April 9, 2024

The following are Public Health's comments on the SP-24-00005 Mohar Notice of Application.

MOHAR FARM SHORT PLAT

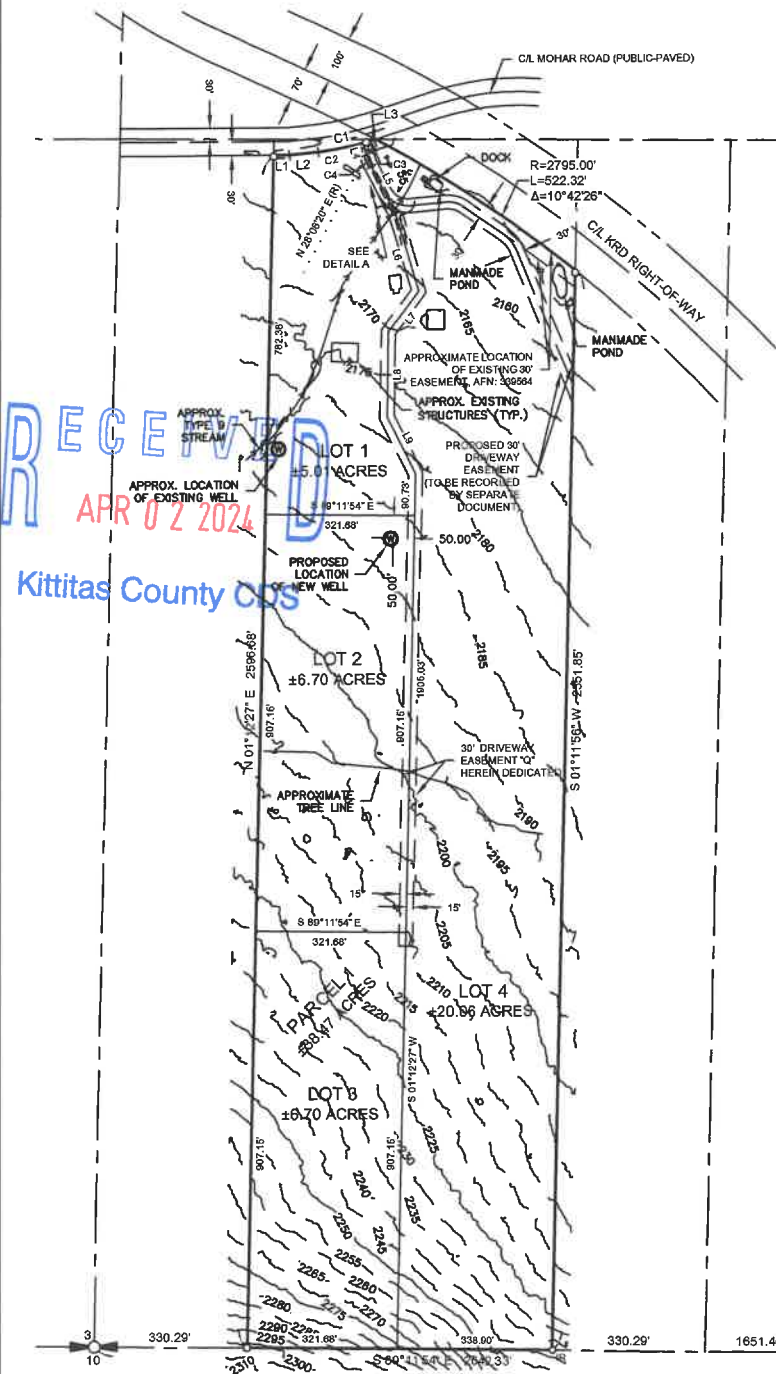
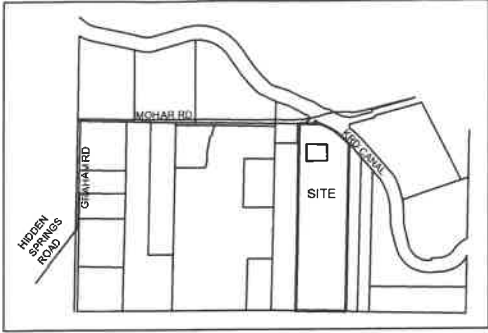
1. KCC 13.20.04 requires a well for a Shared or Group B Water System to have a recorded easement granting access to the well, pump house and pipeline to the future owners of the water system.

2. Chapter 246-272A-0323 WAC requires configuration of each lot to allow a one hundred-foot radius water supply protection zone to fit within the lot lines; or establishment of a one hundred-foot protection zone around each existing and proposed well site.

3. A signed, notarized and recorded two party shared well users' agreement between each of the lots to be served by the individual wells and well logs for the existing well on lot 1 and proposed well on lot 2 must be submitted to the Health Department for review.

4. If individual wells are to serve each of the proposed lots a well needs to be drilled on lots 3 and 4 and a well log needs to be submitted for each of the proposed lots.

5. KCC 13.04.090 requires at least one soil log to a depth of six feet to be performed at the site of each disposal area on each proposed lot.
